Byers Gill Solar EN010139

3.3 DCO Schedule of Changes

Revision 8

January 2025

Drawing Title
Street Works, Public Rights of Way & Access Plans
Sheet 11 of 13
APFP Regulation 5(2)(k)

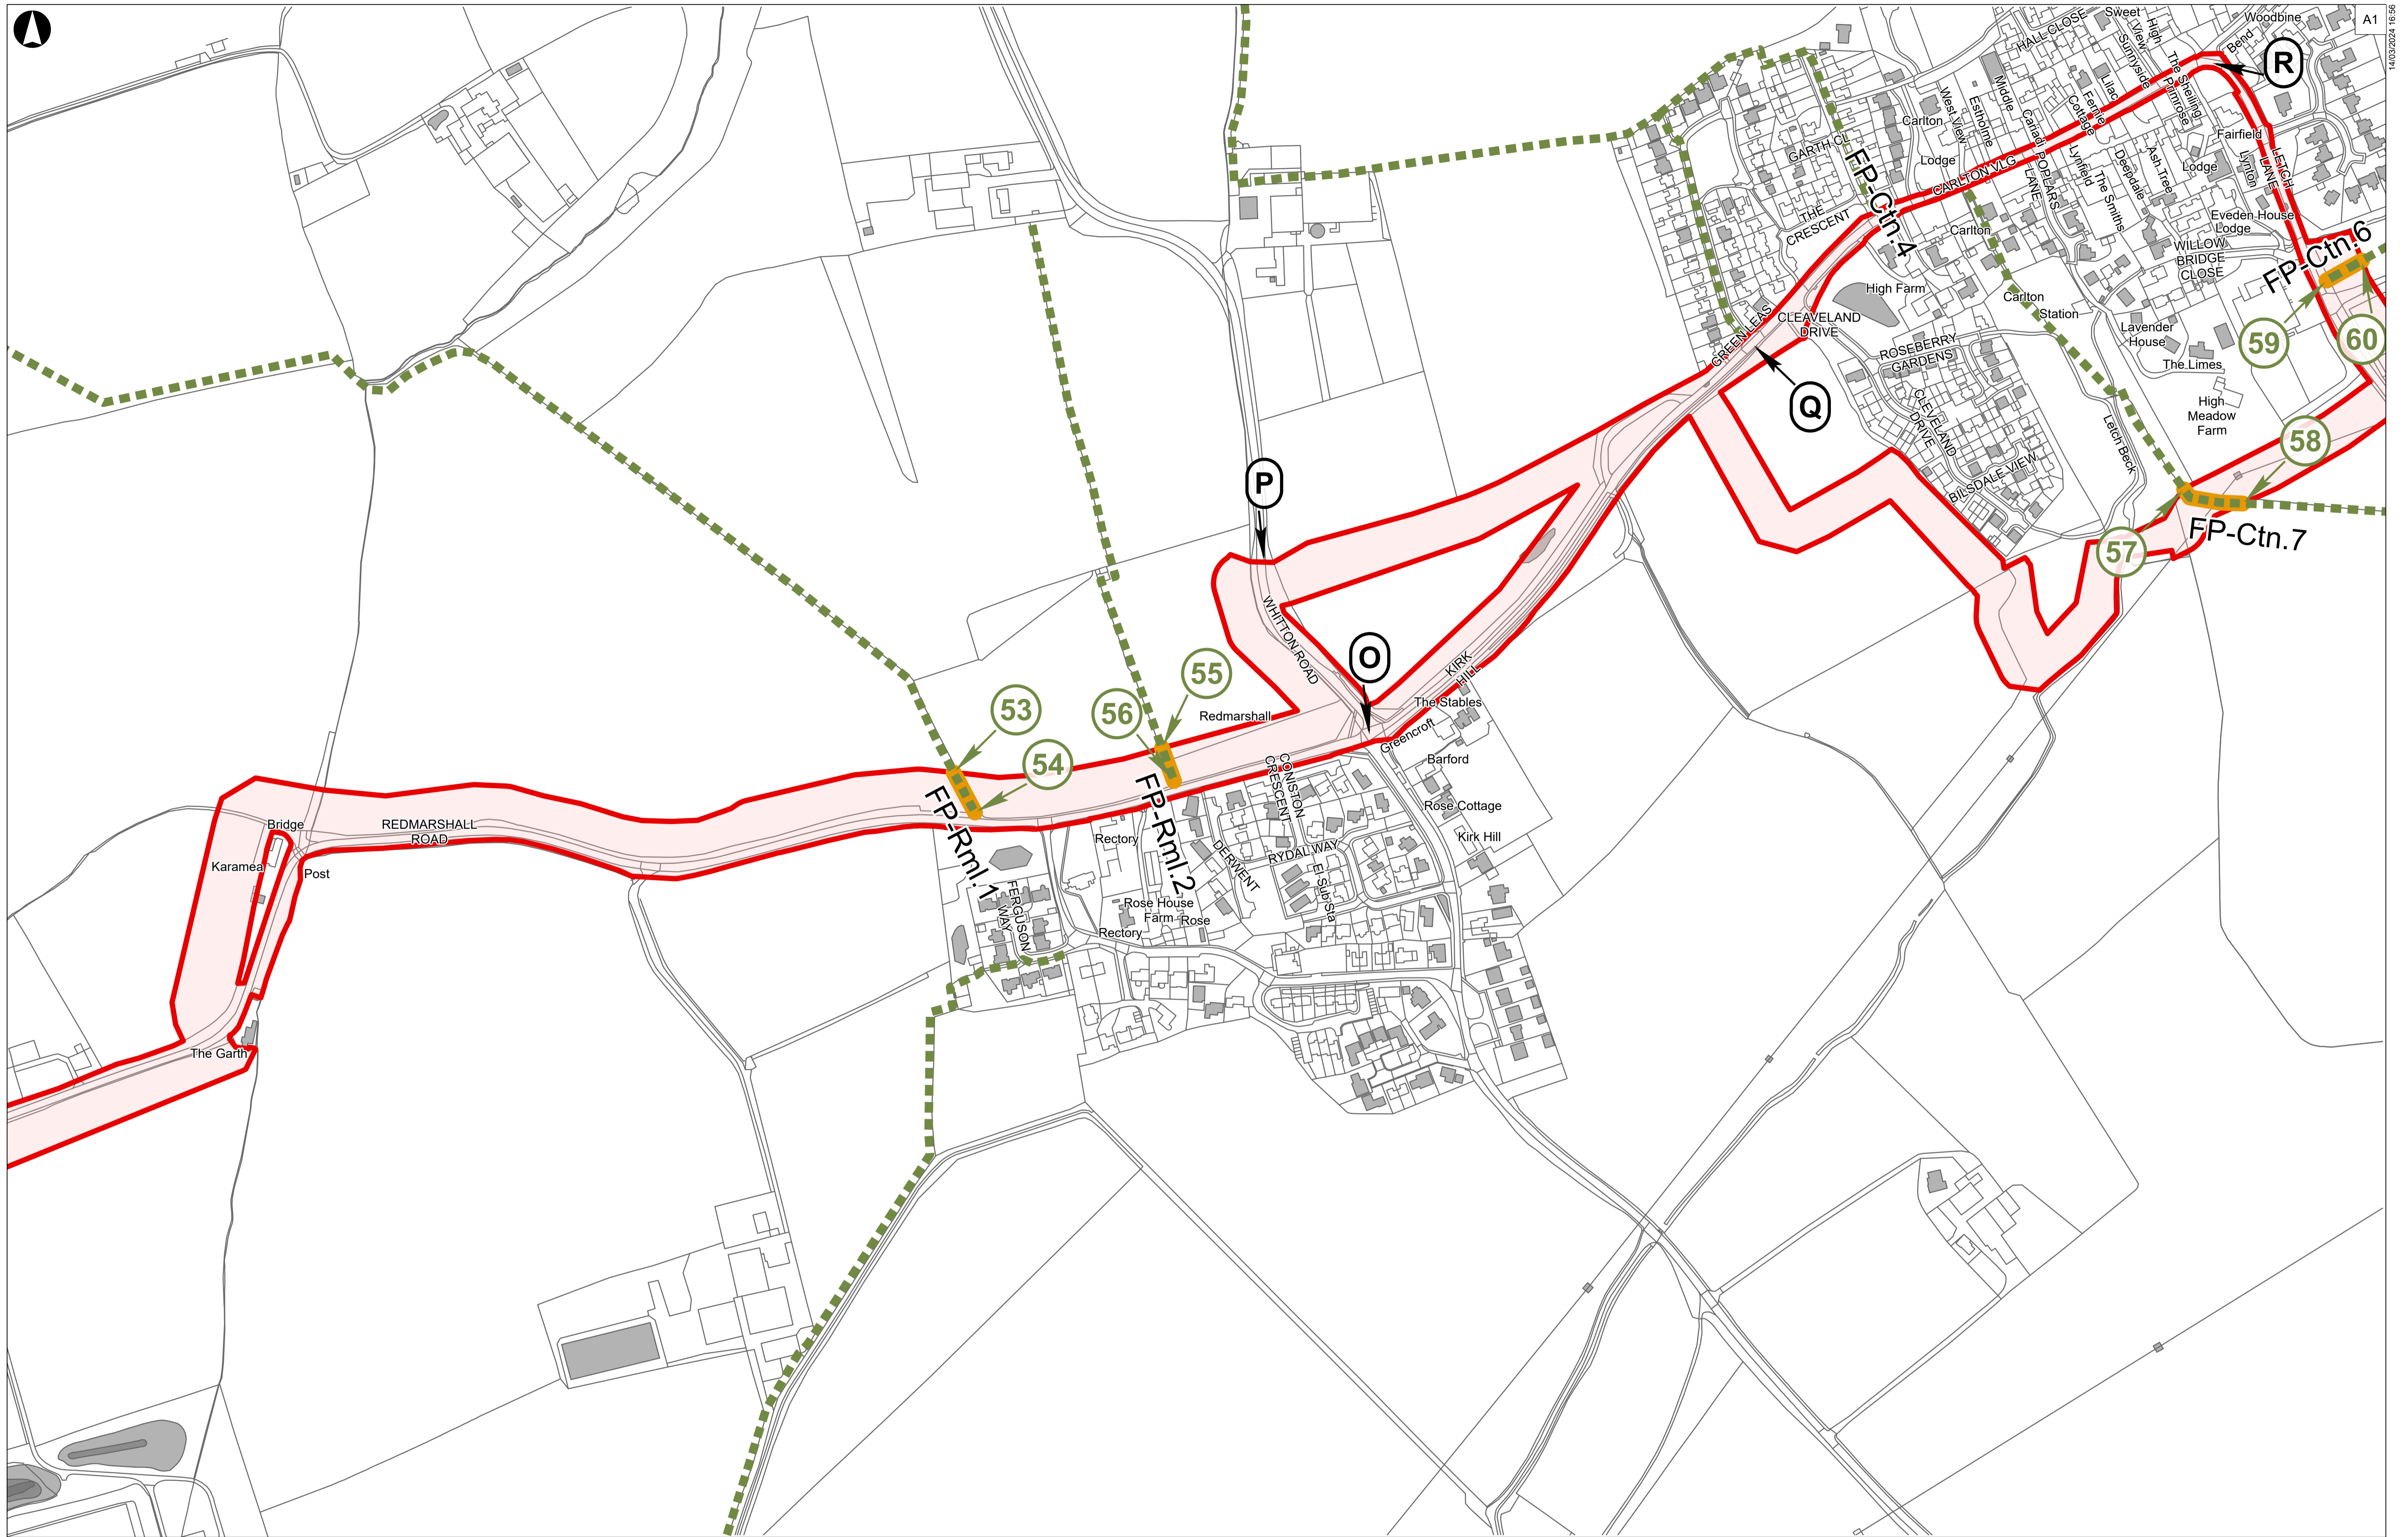
| <u>Parish of Redmarshall</u> | <u>Redmarshall Road, in the vicinity of Morrington Bridge</u> | <u>Cable works beneath the width of street as shown with reference CC6 on sheet 11 of the street works, public rights of way and access plans.</u> |

These two rows have been added to provide street works descriptions for two locations where the Applicant proposes to carry out cabling works across the width of a street for the purpose of delivering the off-road cable route. These descriptions are included as a correction to Revision 1 of the dDCO.

Corresponding amendments have been made to the Street Works, Public Rights of Way and Access Plans to indicate these locations.
